EPC STORMWATER REVIEW COMMENTS IN ORANGE BOXES WITH BLACK TEXT

OVERALL ALTERNATIVE LANDSCAPE PLAN

The Shire At Old Ranch
Howells & Old Ranch Road
Colorado Springs, CO

LS  
4

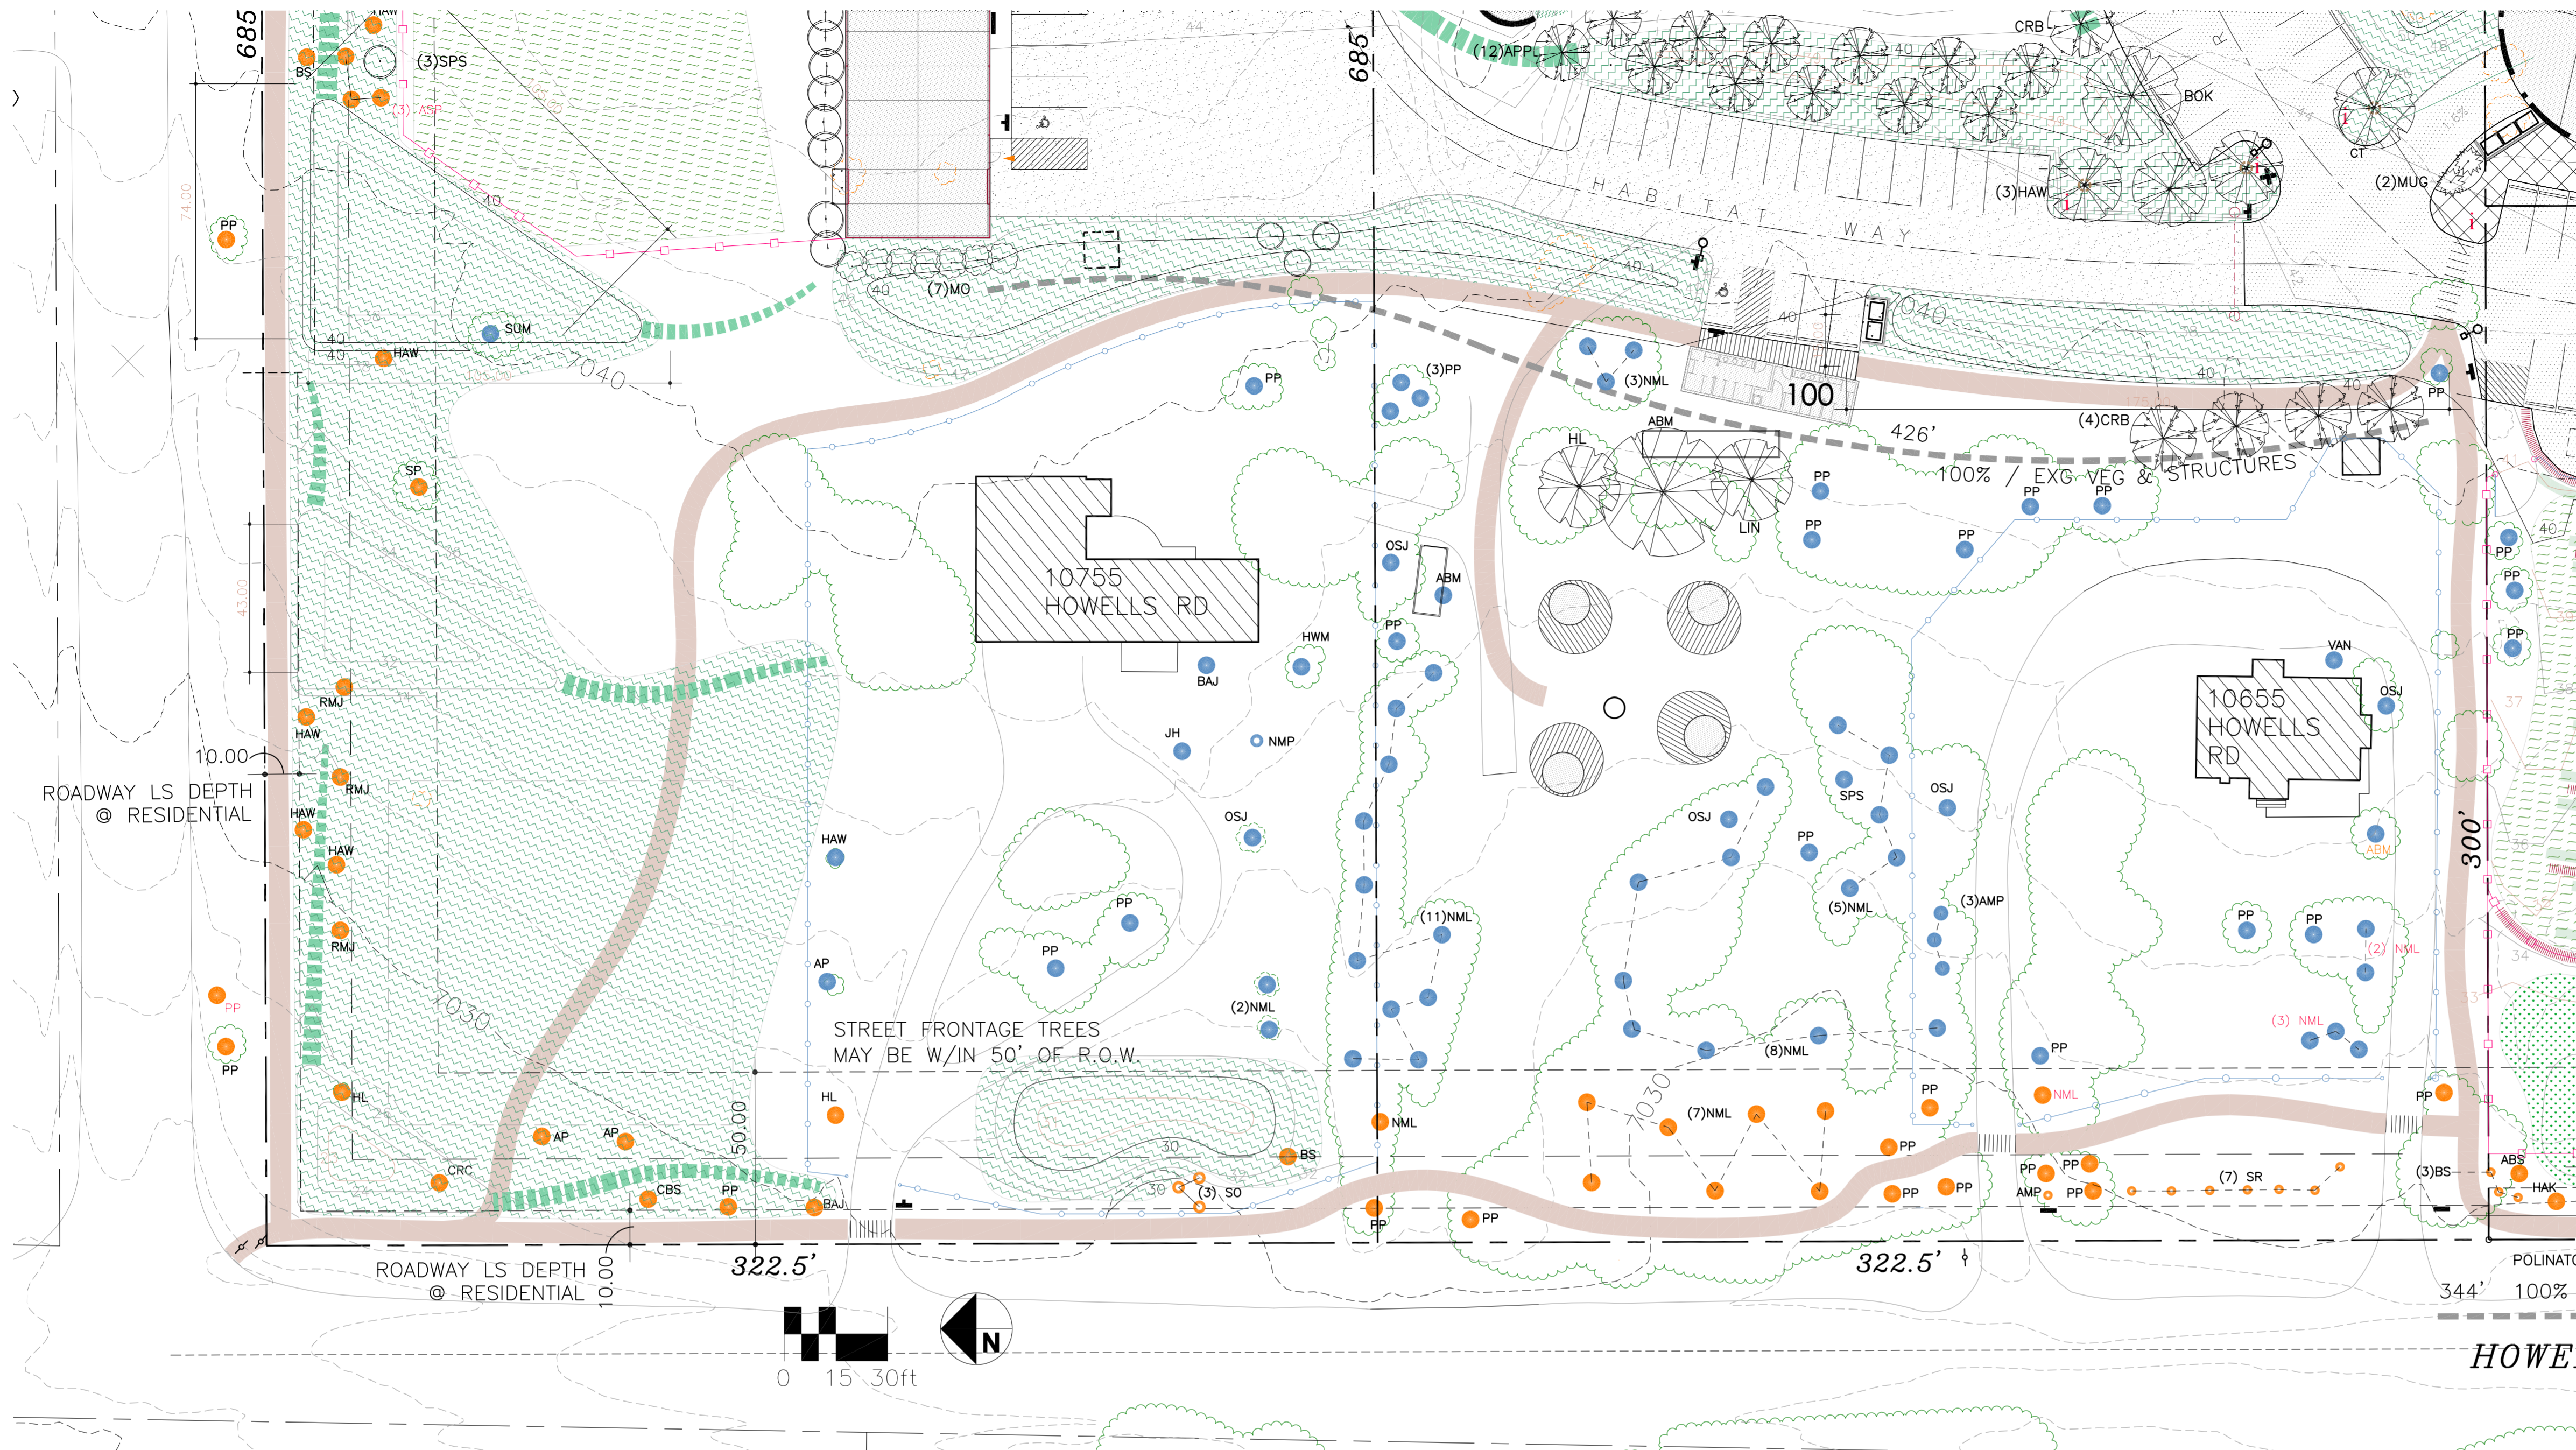
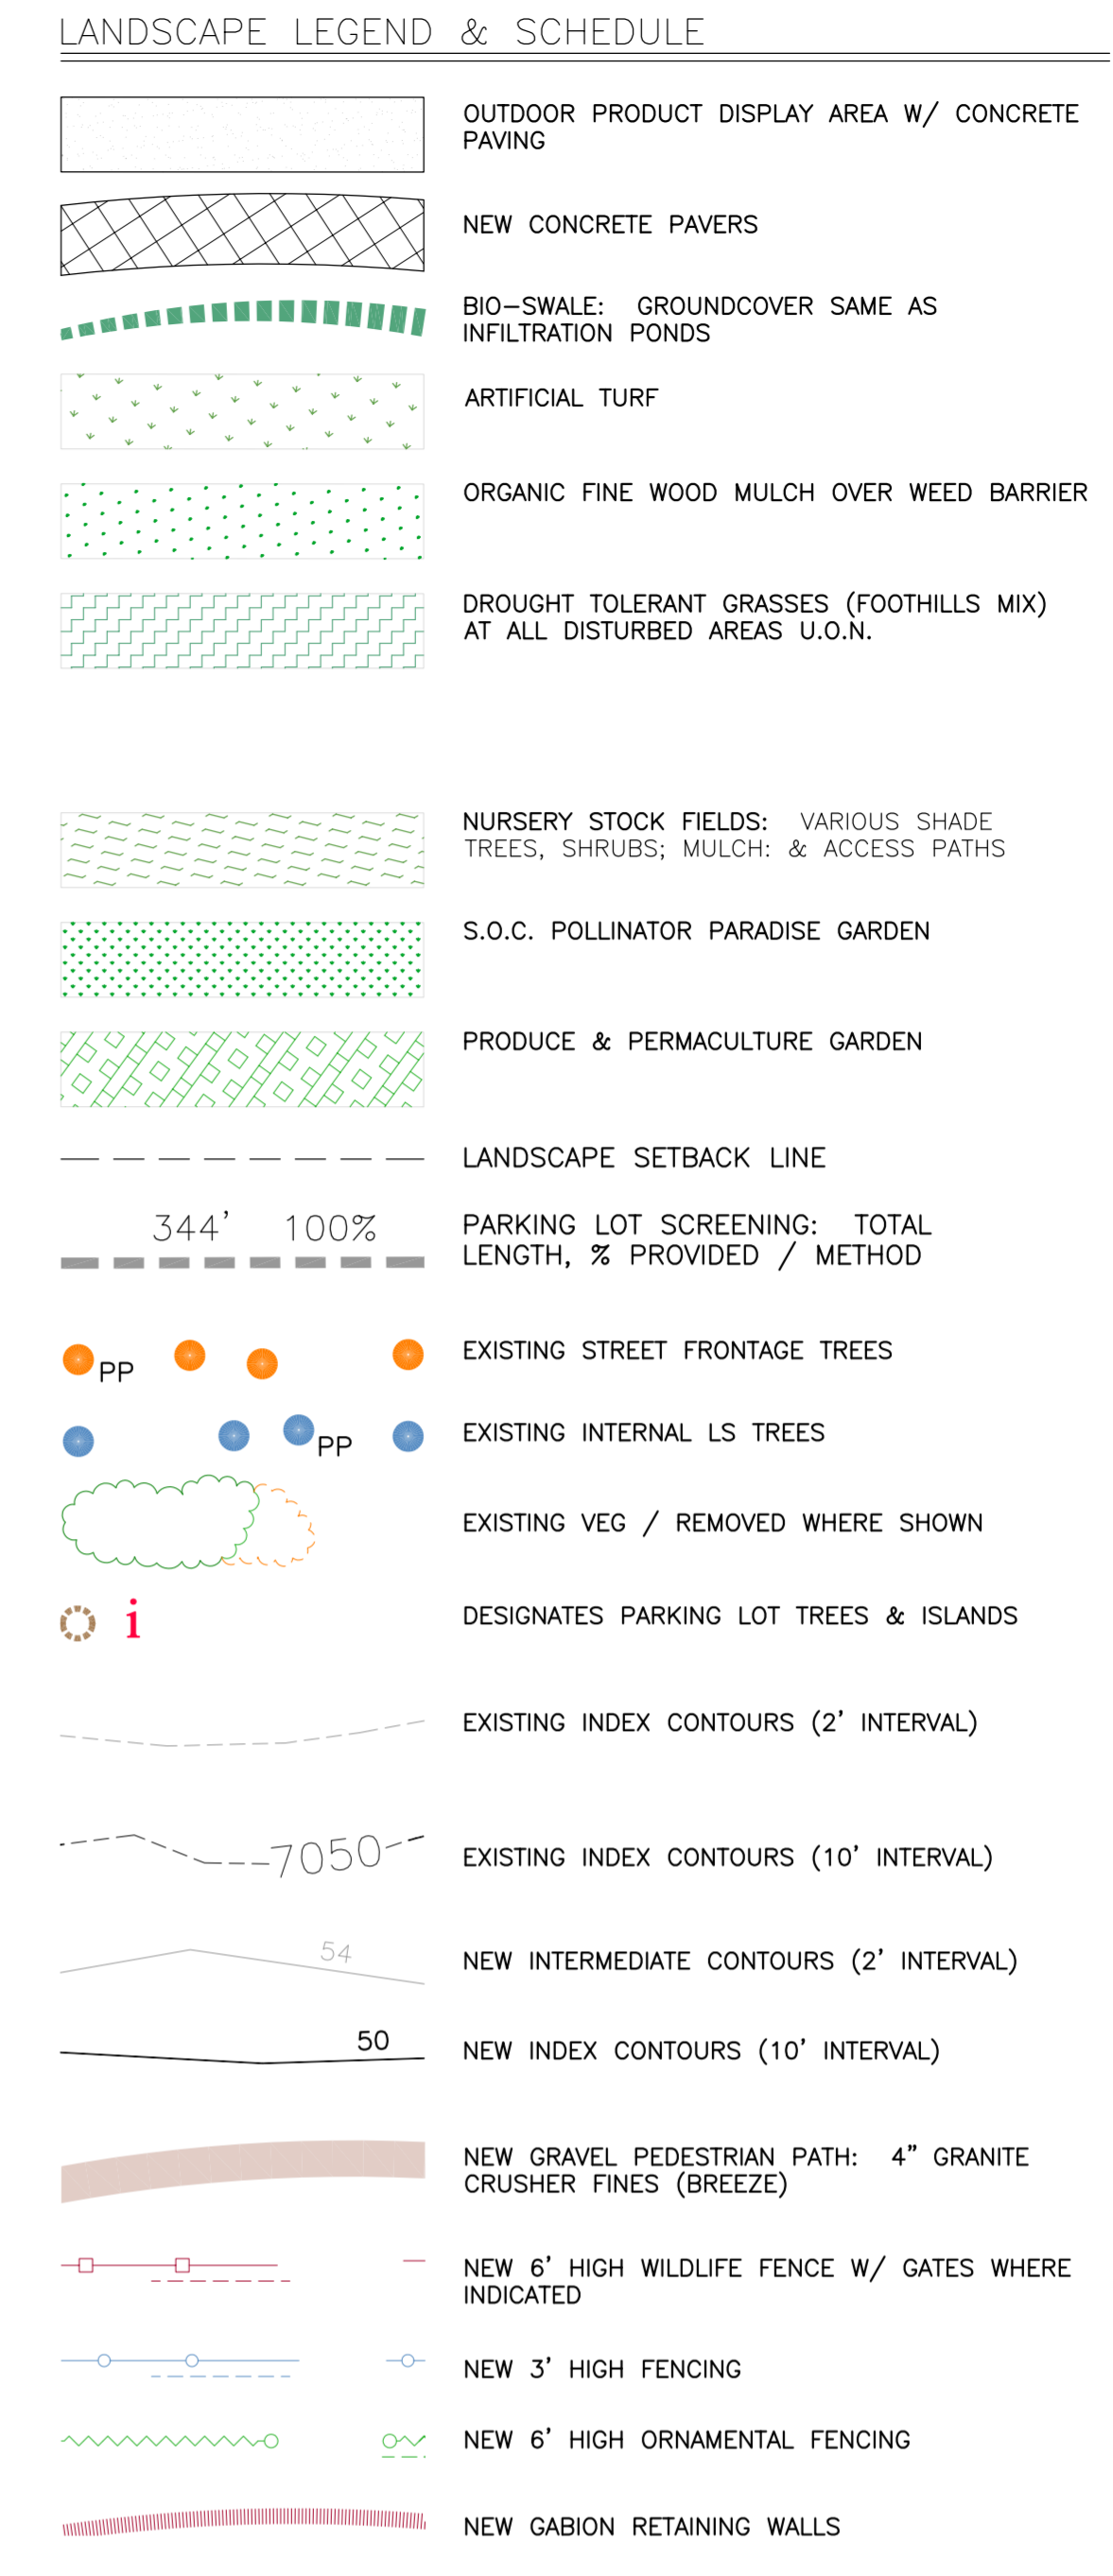
This type of tree is not recommended per the landscape code, please consider planting a different species, what is existing is fine
